PINE VIEW ESTATES FILING NO. 1 PRELIMINARY PLAN

SECTION 13, TWP 11, RANGE 64 WEST OF 6TH PRINCIPLE MERIDIAN
EL PASO COUNTY, COLORADO

PRELIMINARY PLAN

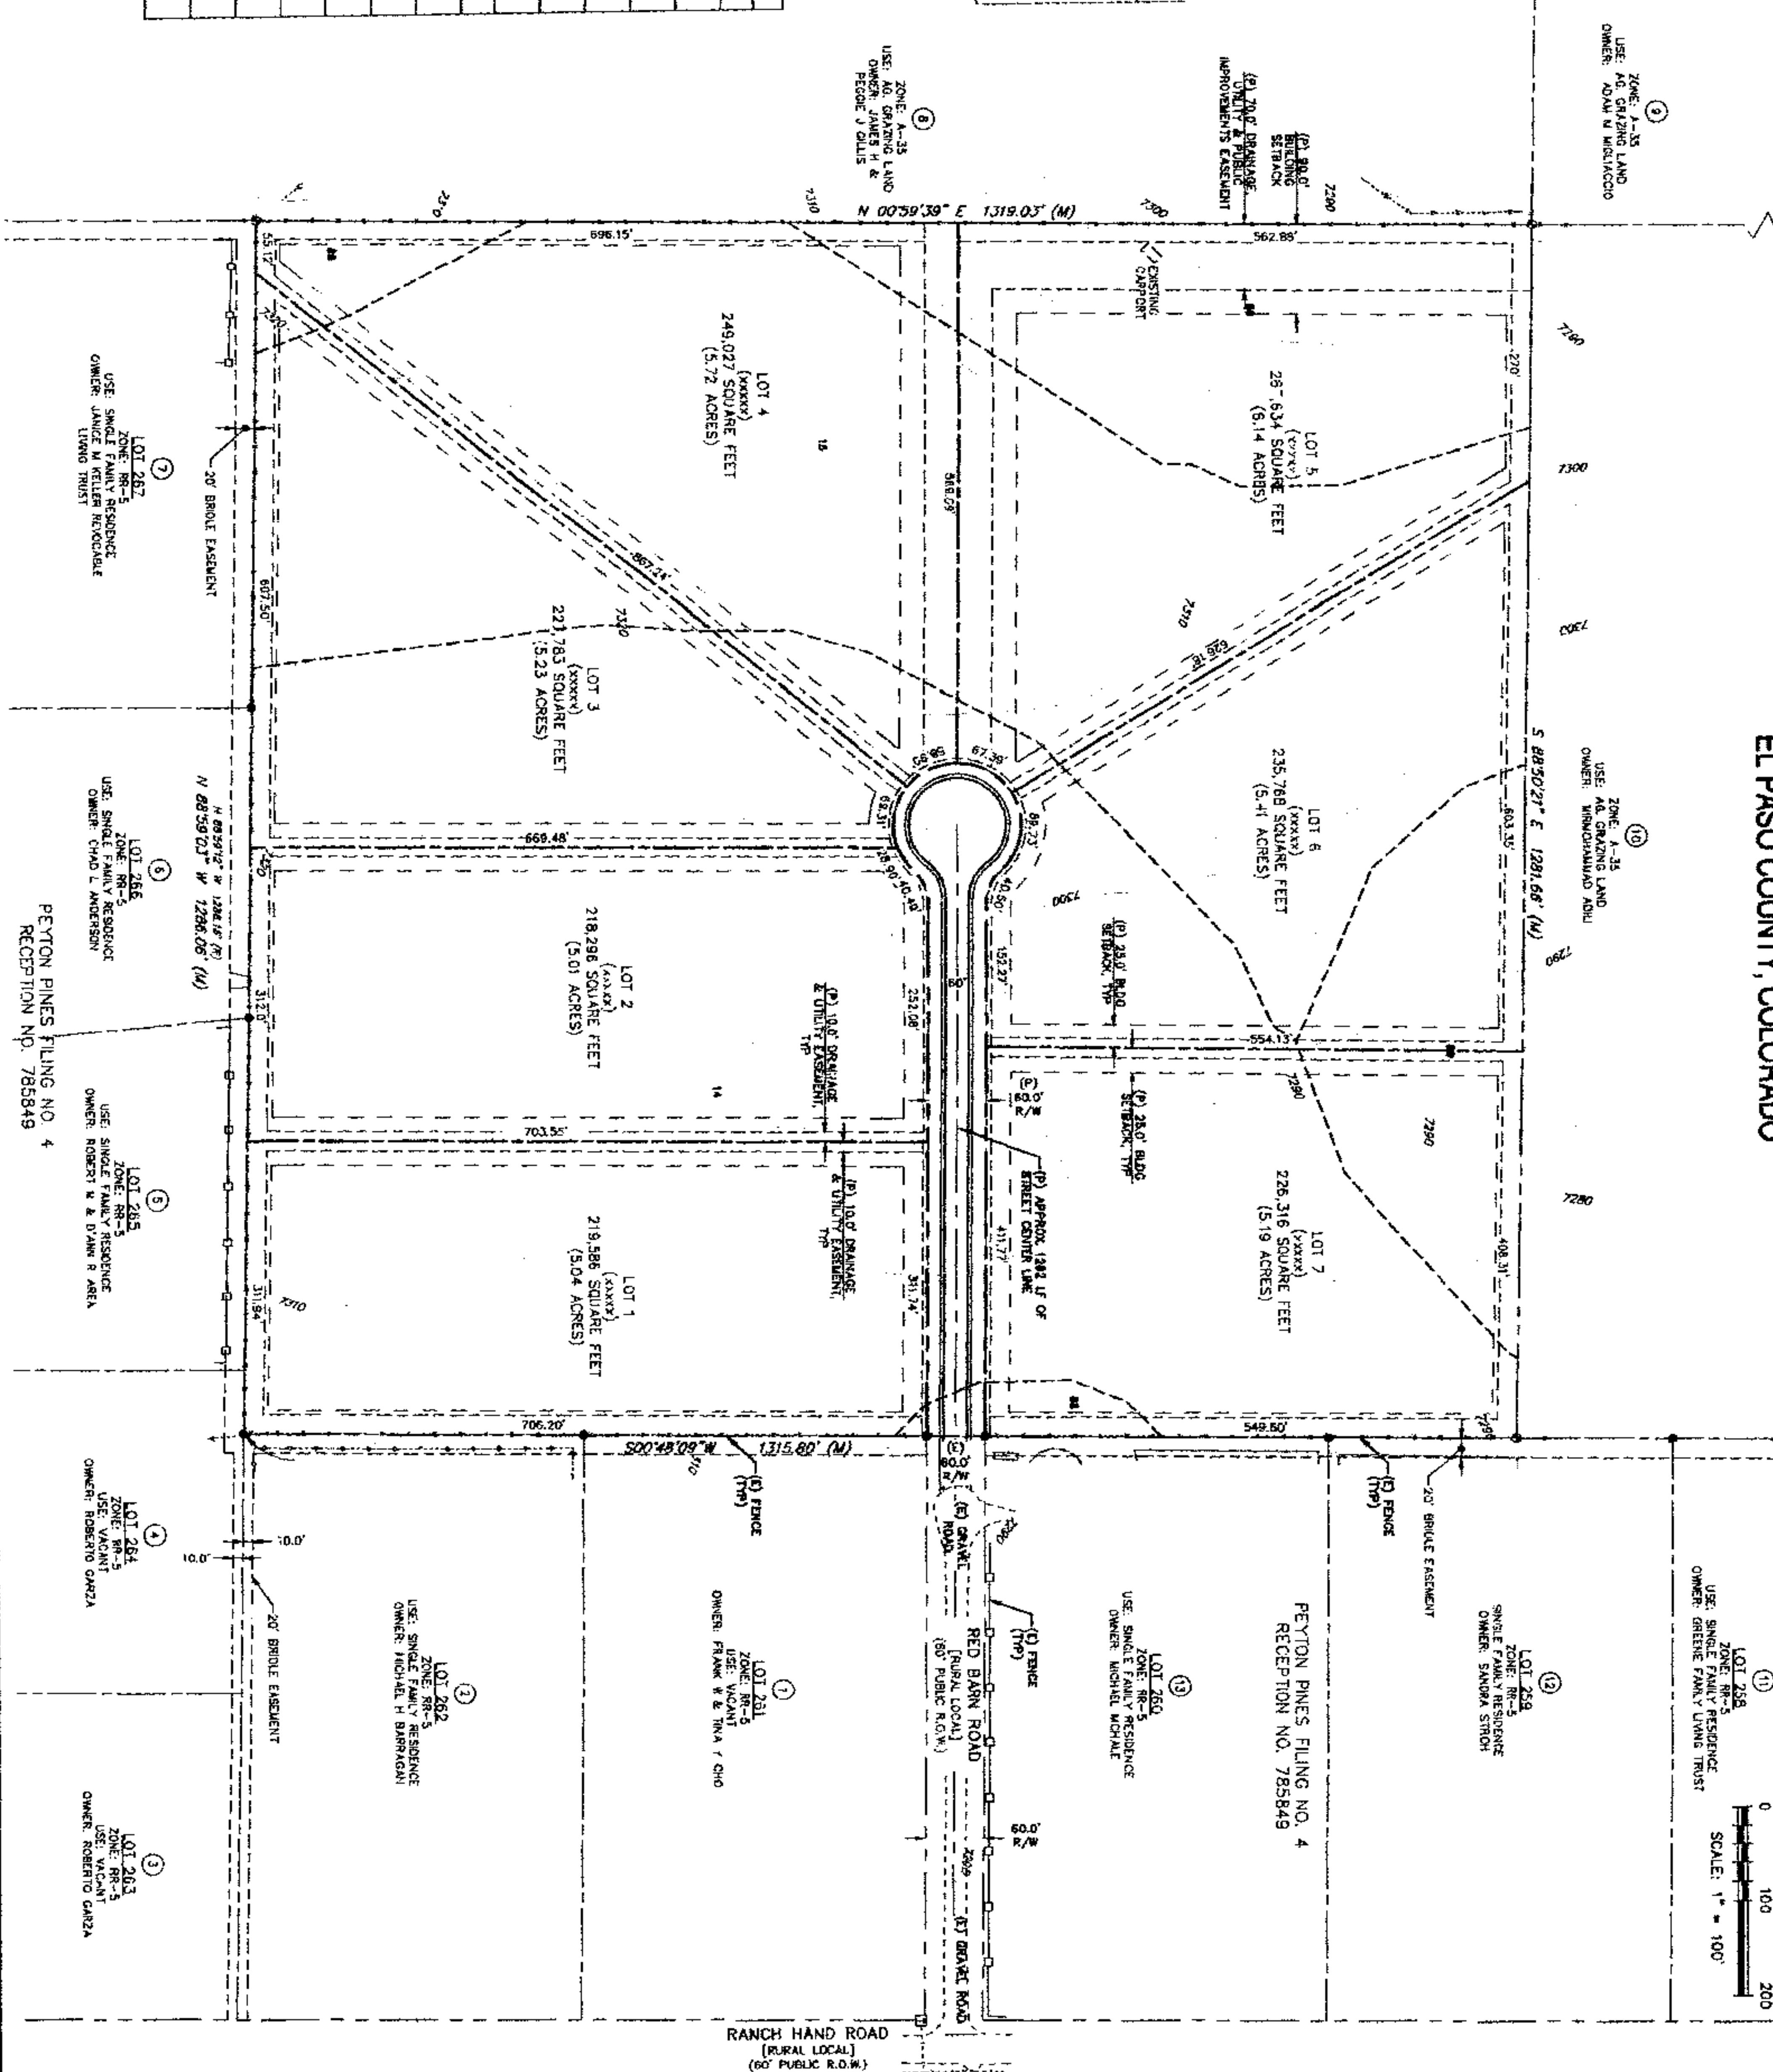
Per direction from the State, subdivision developments that include impervious pavement roads do not qualify for Exclusion E (Large Lot Single-Family Site) Exclusion on the PBMP form. Therefore, some sort of permanent WQ facility should be included in design.

Please add this note and list the reports that have been provided for review with the Preliminary Plan as applicable.

Response: Gravel Roadway proposed. Runoff reduction from roadway included in drainage report exceeds 60% of WQCV.

Response: Note as requested has been added to the drawing.

Response: A 200' wide bldg setback has been added to lots 3, 4 & 5 as requested.

Response: The lines have been labeled and dimensioned as requested.

Response: The note has been revised to reflect a future 70' r/w at no cost to county.

Response: The soil type information has been added to the legend as requested.
